**KIRKLEES METROPOLITAN COUNCIL
INVESTMENT & REGENERATION SERVICE**

DELEGATED DECISION TO DETERMINE PLANNING APPLICATIONS

Reference No:	2025/62/92319/E
Site Address:	4, King Edward Street, Thornhill Lees, Dewsbury, WF12 9EY
Description:	Erection of single storey rear extension and associated alterations
Recommending Officer:	Faiza Bano

HOUSEHOLDER DELEGATED REPORT

001 - PROPOSED FLOOR PLANS

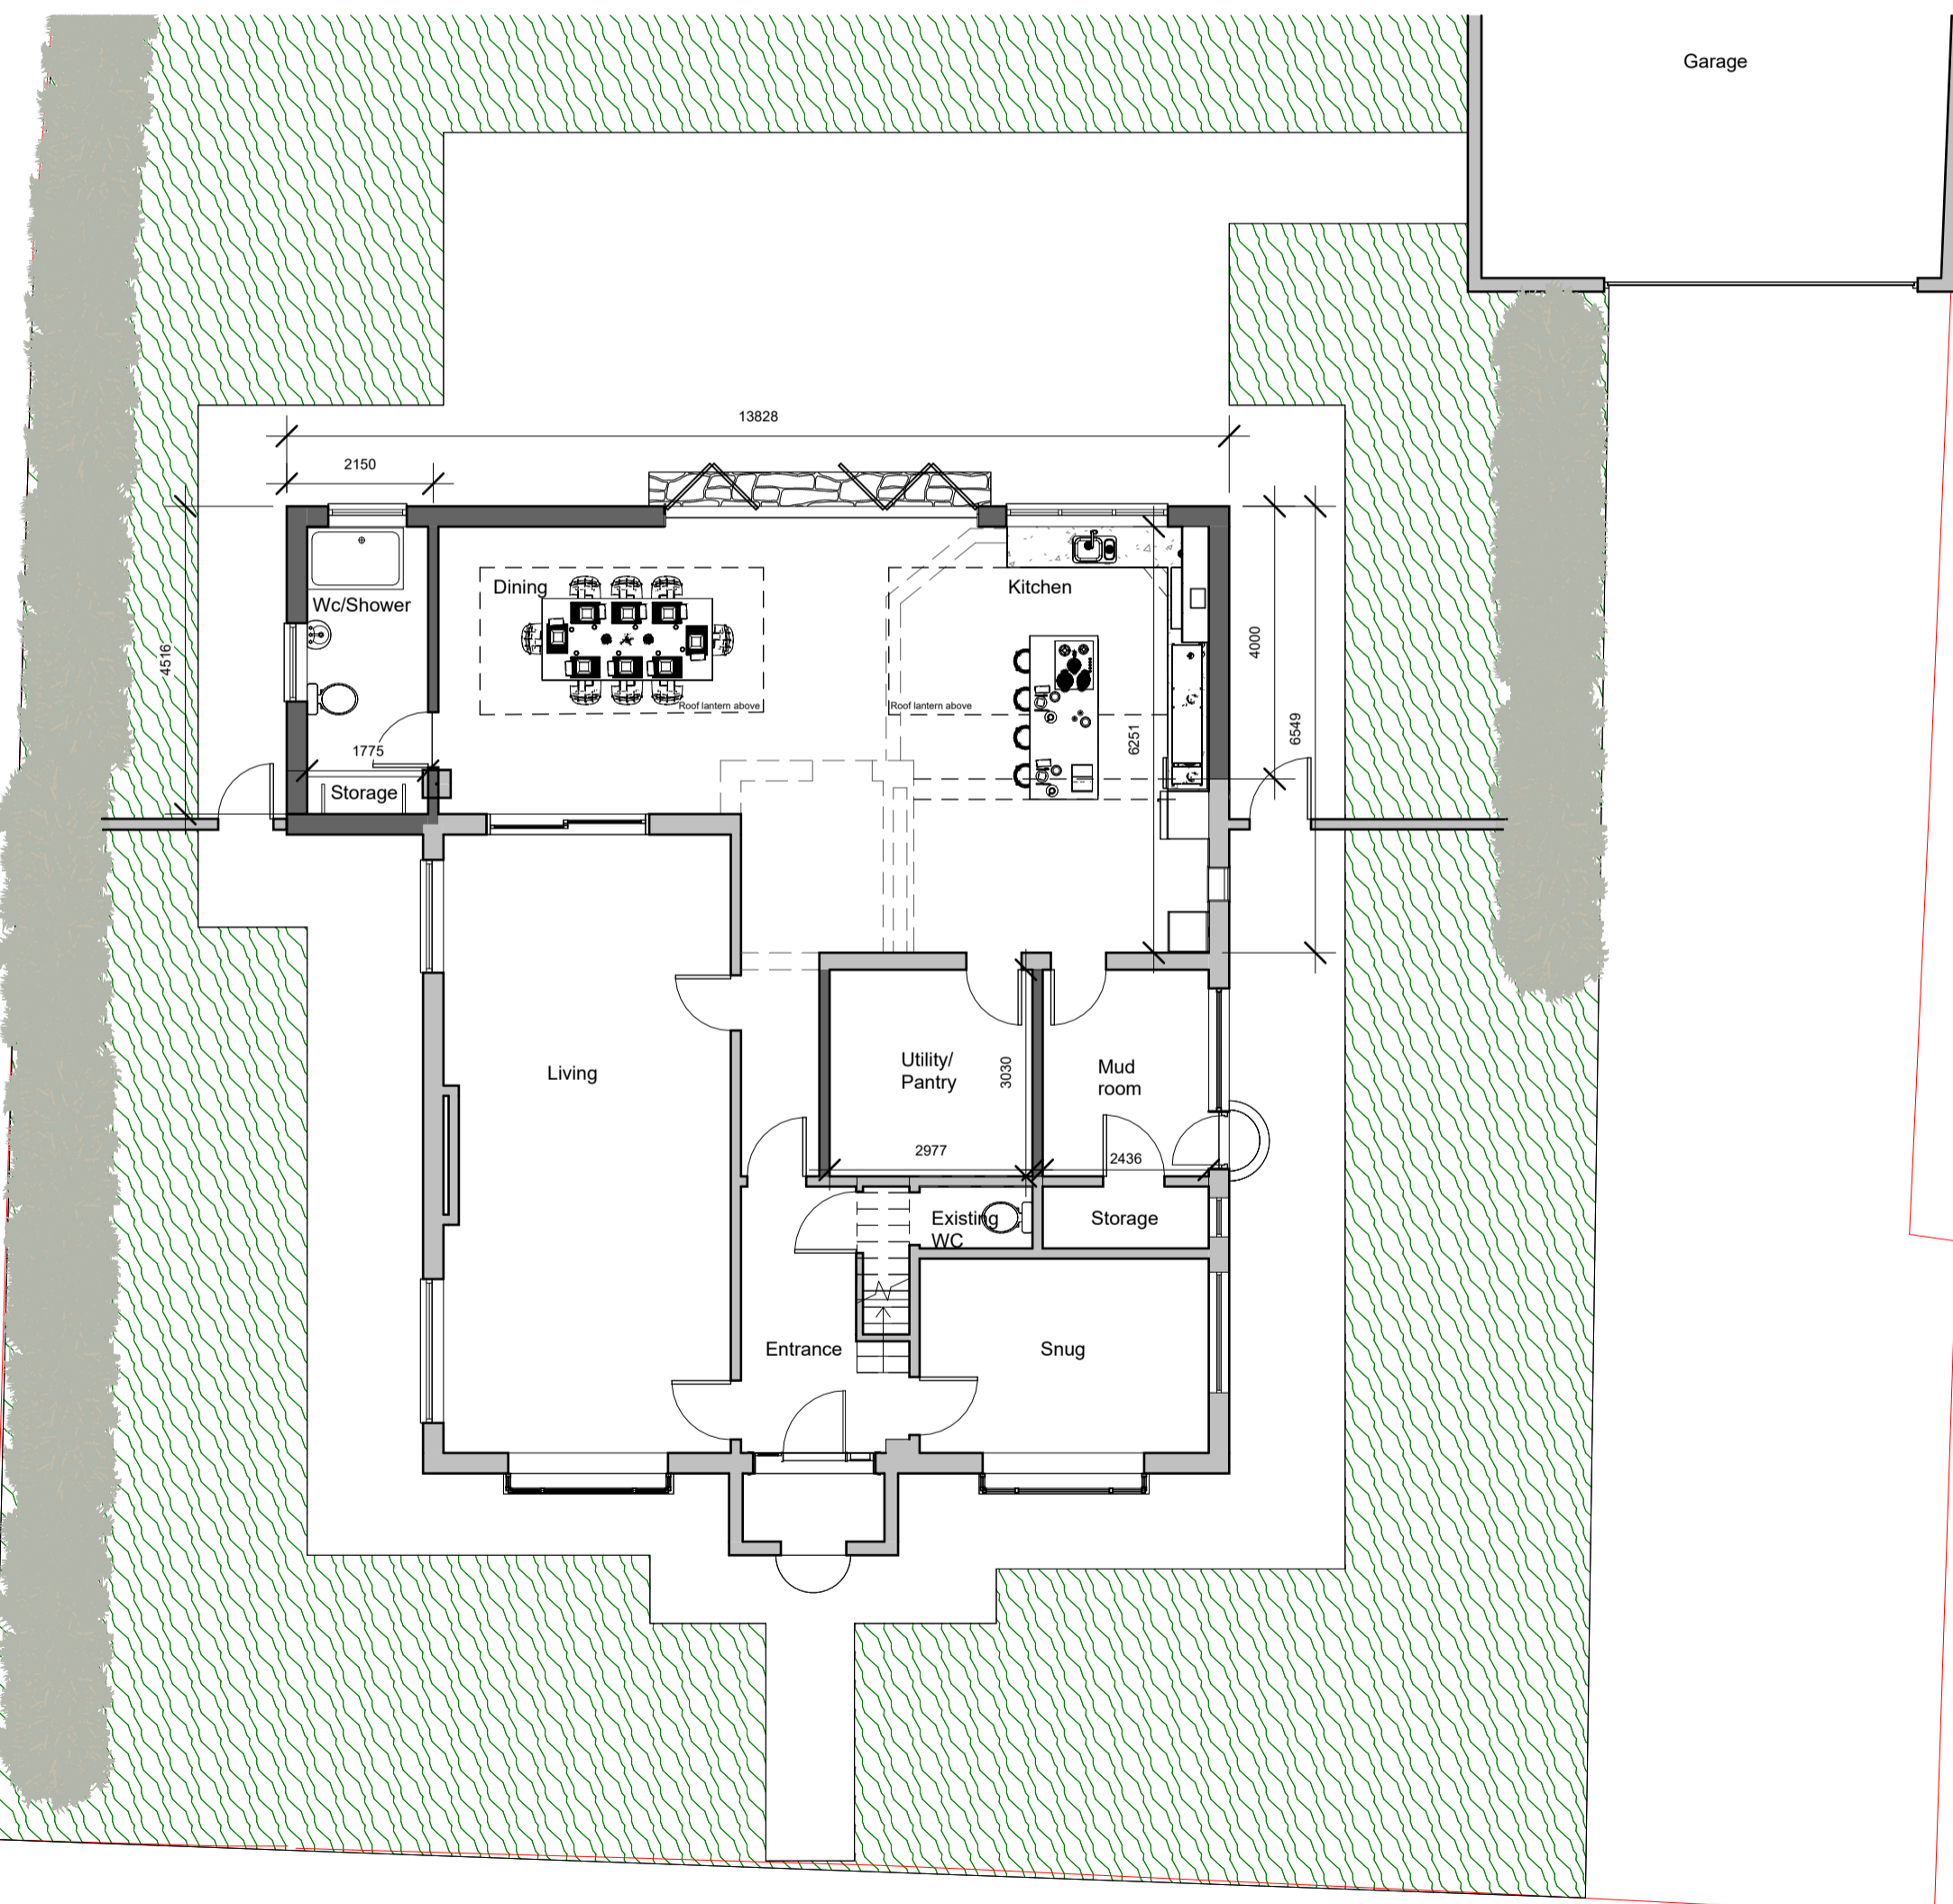
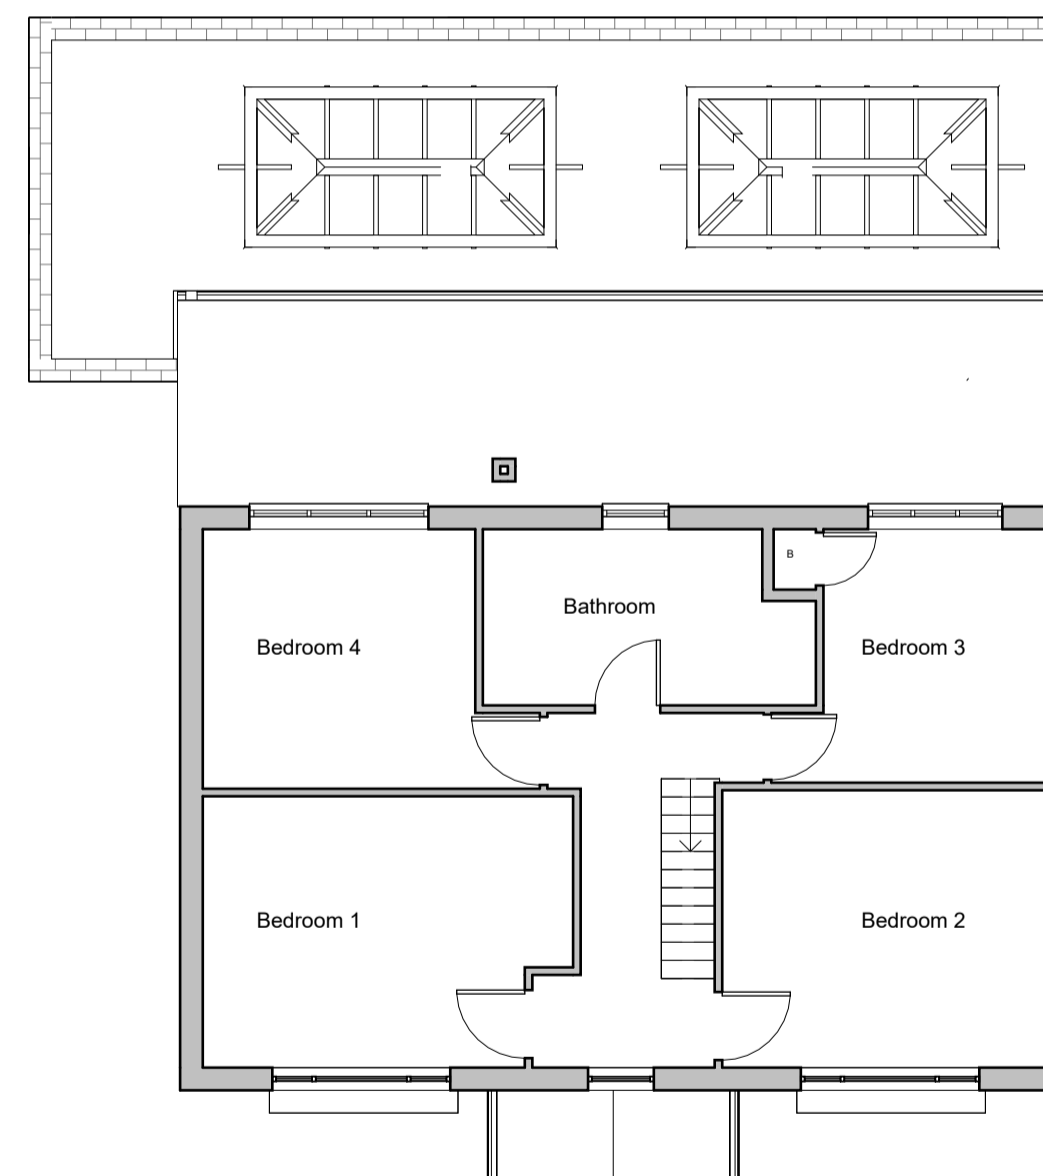
not project out more than 3 metres from the rear wall of the original house for semi-detached and terraces houses or by 4 metres for detached properties;		No – The extension has a maximum projection of 4.5 metres (at the wrap around section) from the original rear elevation and spans the total width of the dwelling. The 4.5 metre projection is considered acceptable as the modest height and single-storey nature of the proposal help

to mitigate any potential overbearing impact on neighbouring properties. Given the scale of the development in relation to the host dwelling and the separation distance from the shared boundary, the proposal is not considered to result in significant harm to residential amenity. The extension is therefore deemed acceptable.
where they exceed 3m in length the eaves height should generally not exceed 2.5 meters; and	Yes – the extension is flat roofed and has an overall height of 3.3 metres, which includes the roof lantern.	
retain a gap of at least 1 metre from a property boundary, such as a wall, fence or hedge.	Yes – the extension retains over a 1 metre gap.

- 2 King Edward Street – there is over a metre distance between the shared boundary of these properties and the rear building line sits behind the shared boundary line with this property; it is considered that there will be little to no impact on this dwelling.

- 2A King Edward Street – there is over a metre distance between the shared boundary of these properties, and it is considered that there will be little to no impact on this dwelling, although this property shall see additional massing and bulk.

- 6 King Edward Street – there is over a metre distance between the shared boundary of these properties, and it is considered that there will be little to no impact on this dwelling. A large hedge defines the shared boundary and it is considered that this property shall not see the additional massing and bulk unless the hedge is removed.

002 - PROPOSED ELEVATIONS

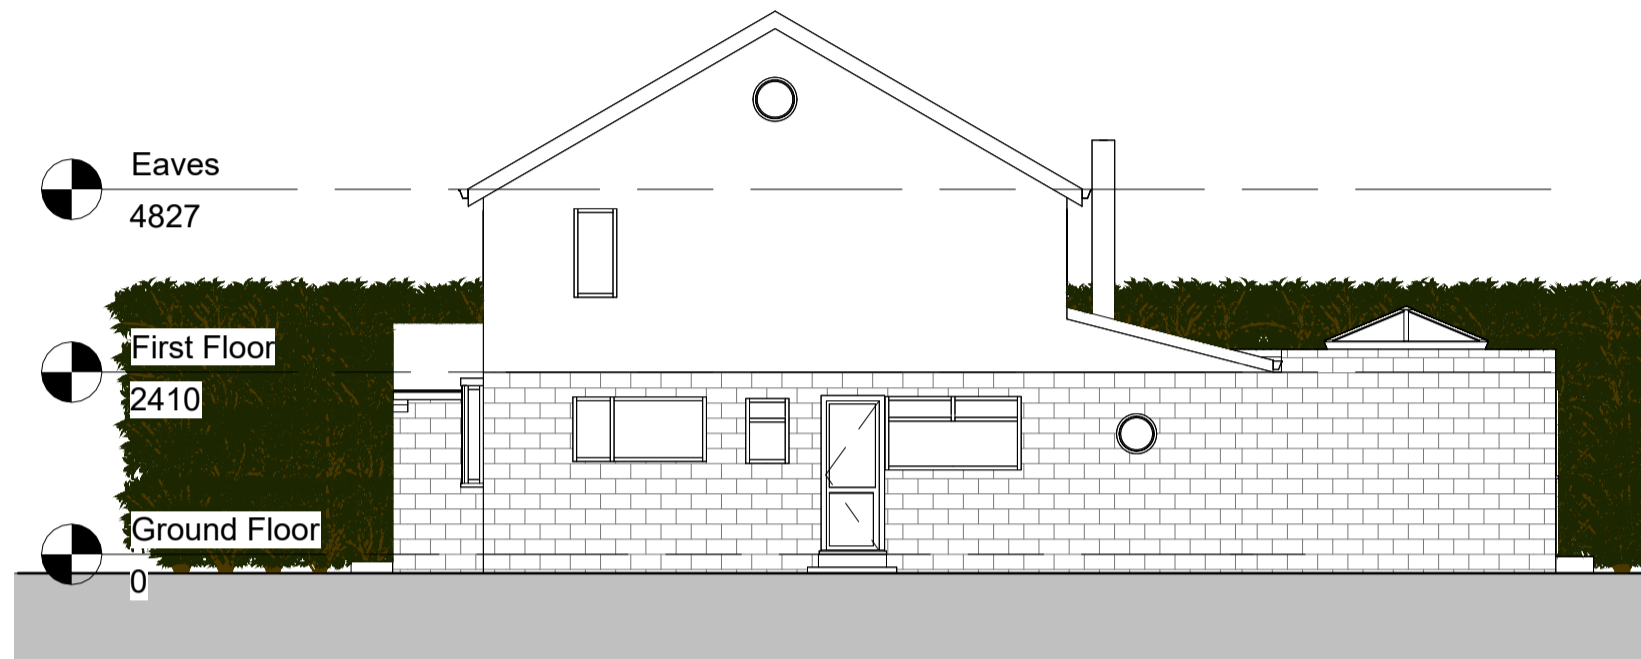
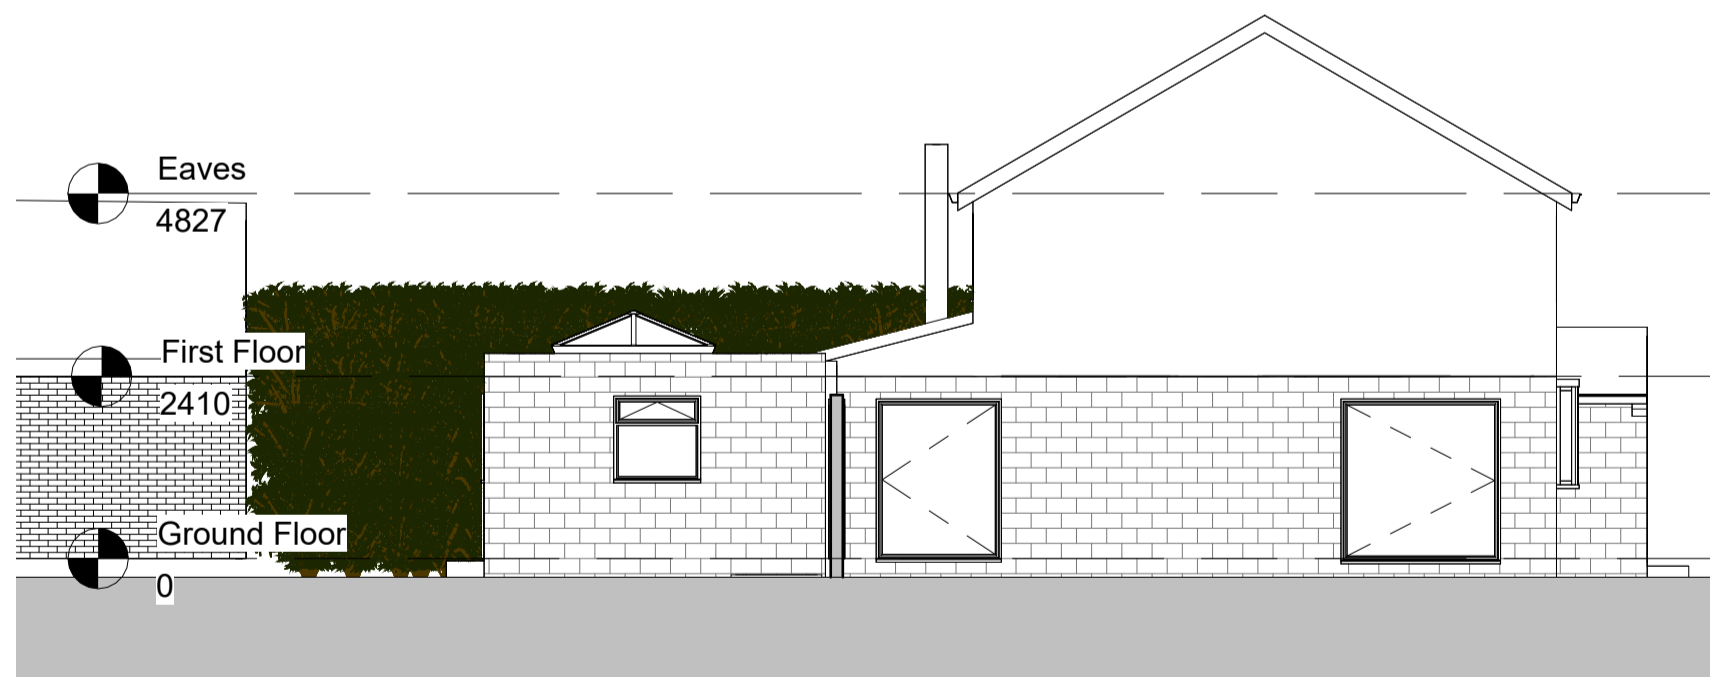
<ul style="list-style-type: none"> • Policy LP24 Design (a) and (c) of the KLP • Chapter 12 NPPF 	appear overly prominent. The proposed development would be located to the rear of the property and will not impact the character or street scene across the frontage of the property.	
Impact on original house	<ul style="list-style-type: none"> • KDP2 of the SPD • Policy LP24 Design (c) and (d) of the KLP • Chapter 12 of the NPPF 	The original property would remain the dominant feature.	✓
Height, scale and massing	<ul style="list-style-type: none"> • KDP 1 and 2 of the SPD • Policy LP24 Design (a), (c) and (d) of the KLP • Chapter 12 of the NPPF 	As above. The extension would project across the rear of the property and is single storey.	✓
Facing materials and detailing	<ul style="list-style-type: none"> • KDP 9 of the SPD • Policy LP24 Design (d) (iii) of the KLP • Chapter 12 of the NPPF 	Facing materials to match existing.	✓

Roof style	<ul style="list-style-type: none"> • KDP 1 and 2 of the SPD • Policy LP24 Design (a), (c) and (d) of the KLP • Chapter 12 of the NPPF 	Flat roof style – acceptable.	✓
Window proportions	<ul style="list-style-type: none"> • KDP 1 and 2 of the SPD • Policy LP24 Design (a), (c) and (d) of the KLP • Chapter 12 of the NPPF 	Modest size windows in rear extension, with floor to ceiling windows and sky lights, which would be in-keeping with existing building.	✓
Accessibility for all users	<ul style="list-style-type: none"> • KDP 17 of the SPD 	Private domestic extension which would	✓

3. The external walling materials of the extension hereby approved shall in all respects match those used in the construction of the existing building.
